# Rezoning Transportation Analysis

Petition Number: #2022-126

Date	Description
12-29-22	First Review (TM)

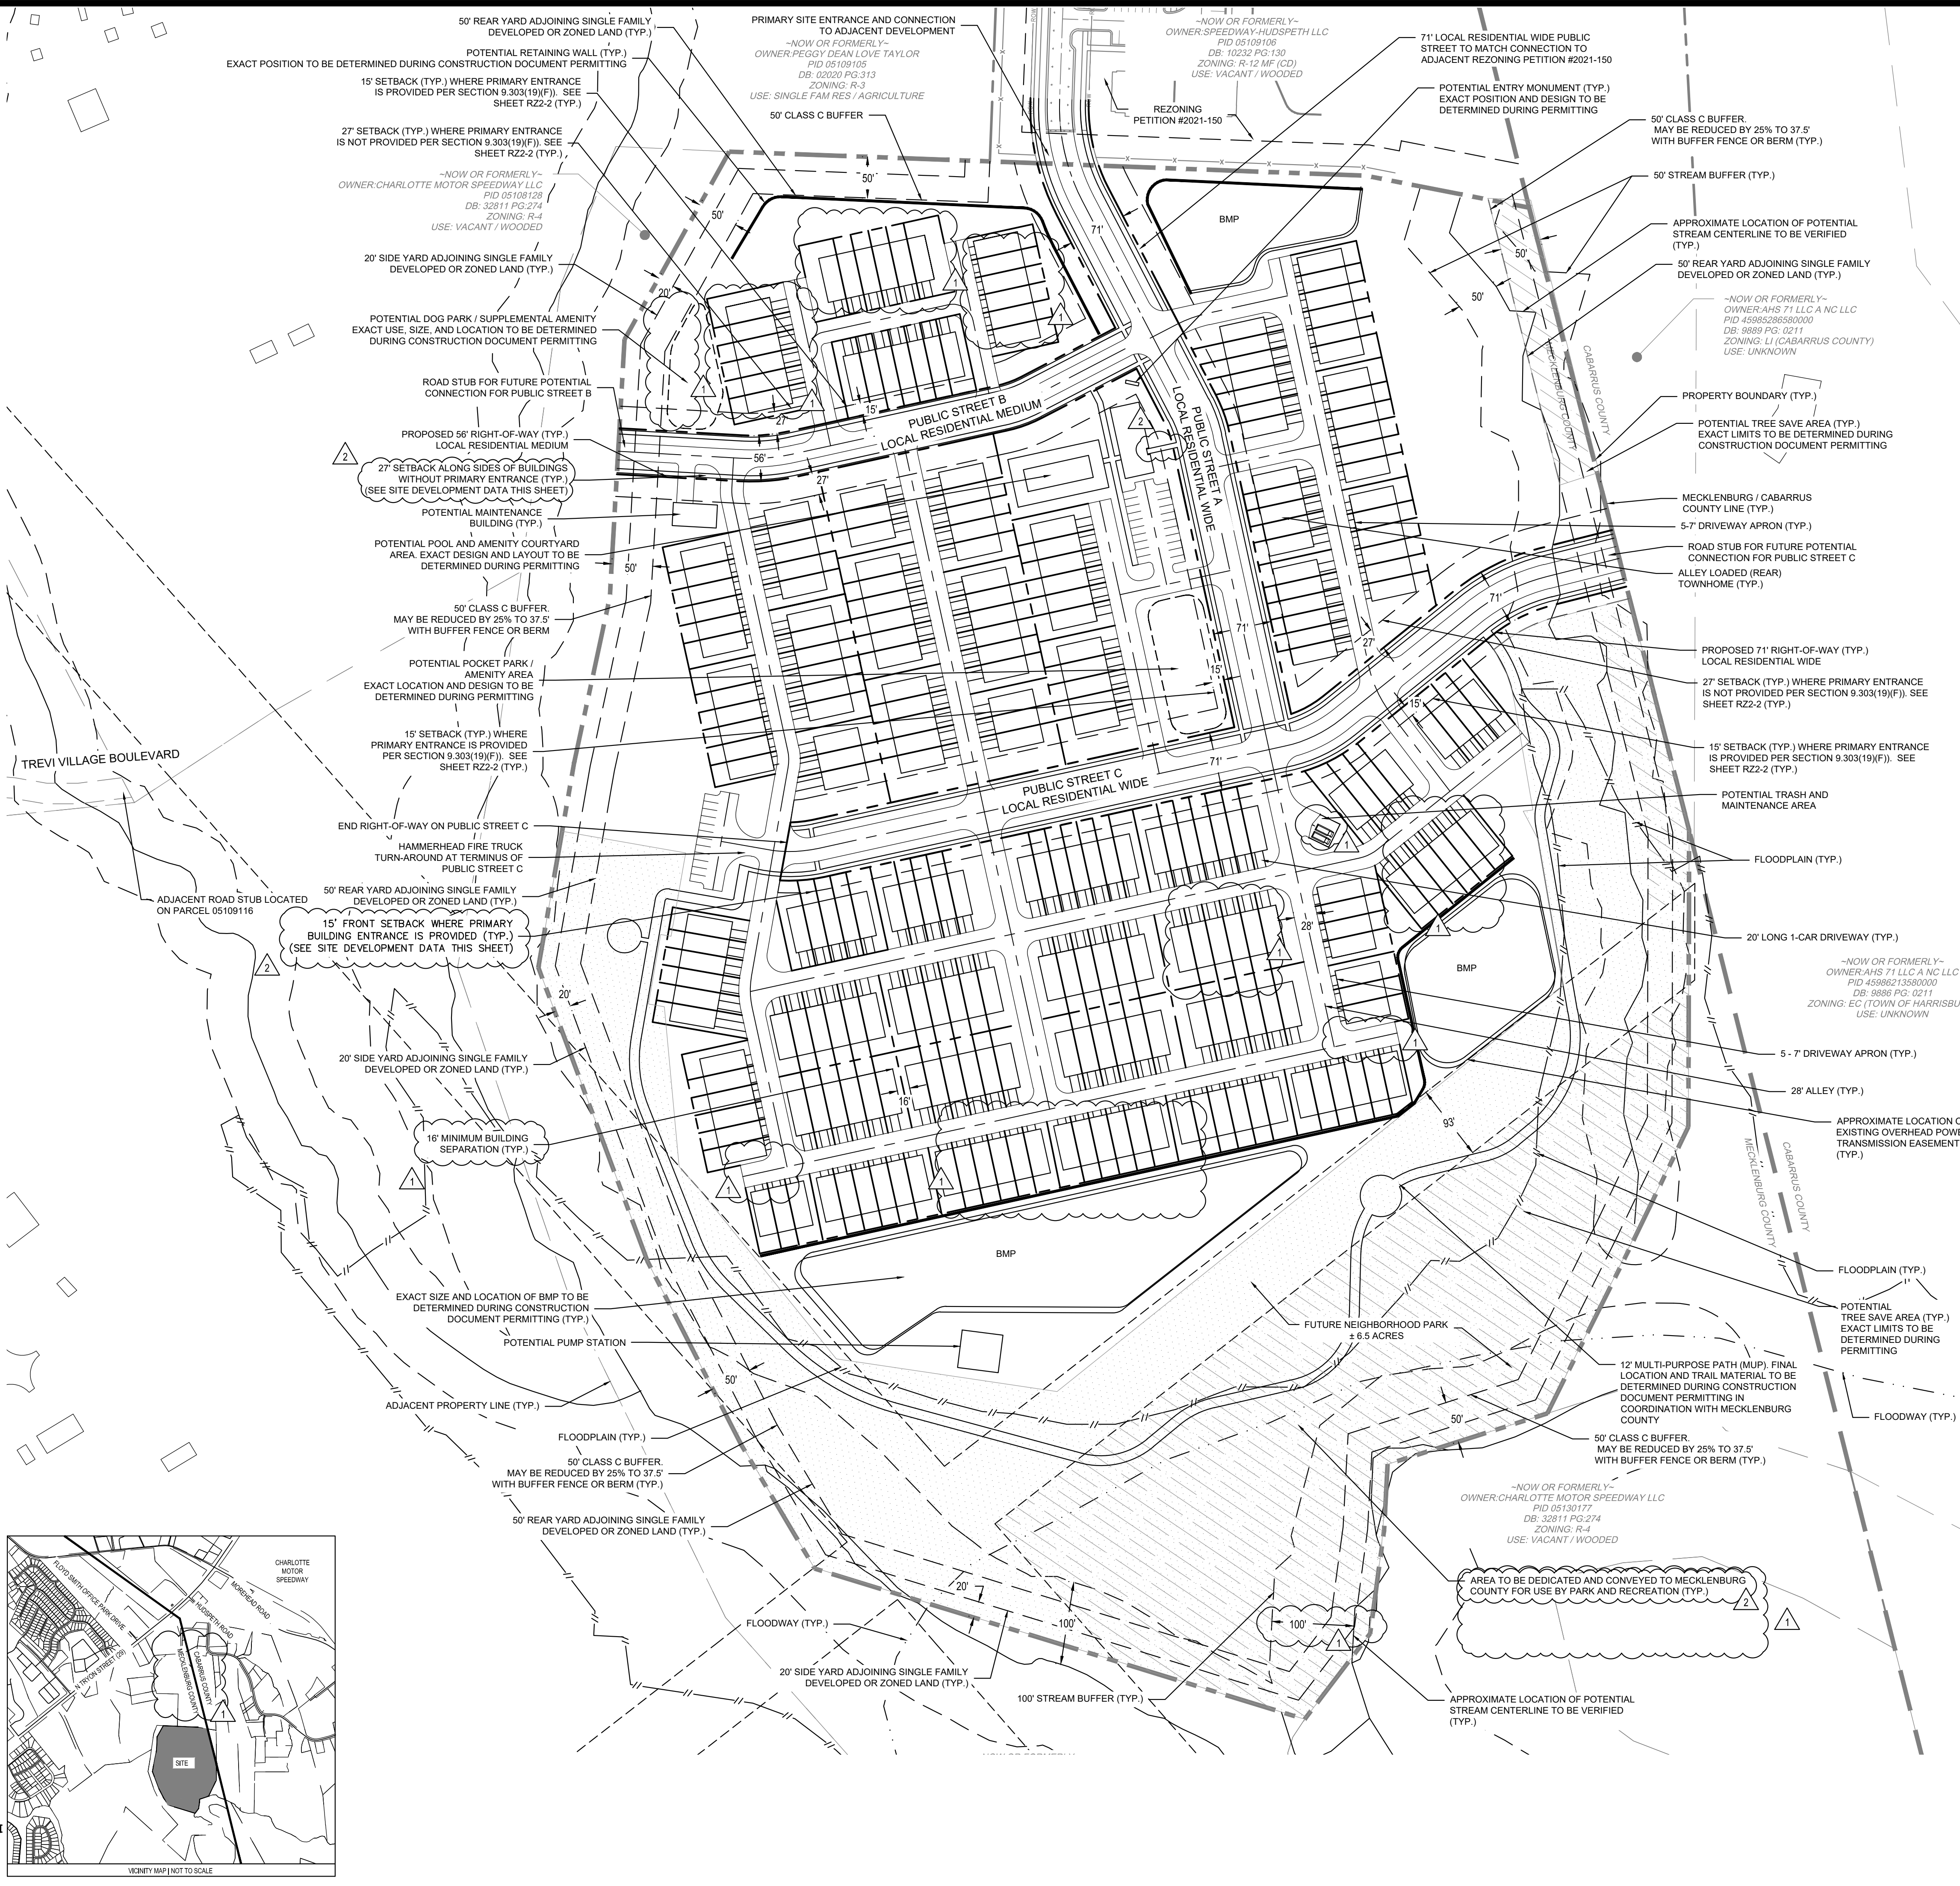
2. Revise site plan and conditional note(s) to commit to construct an 8-foot planting strip, and 6-foot sidewalk on all internal public roads per Chapter 19. The site plan shall label and dimension both items from the back of curb and gutter or edge of pavement.

4. Show entirety of Public Street A as a Local Residential Wide. Add CLDSM roadway typical section for Local Residential Wide.
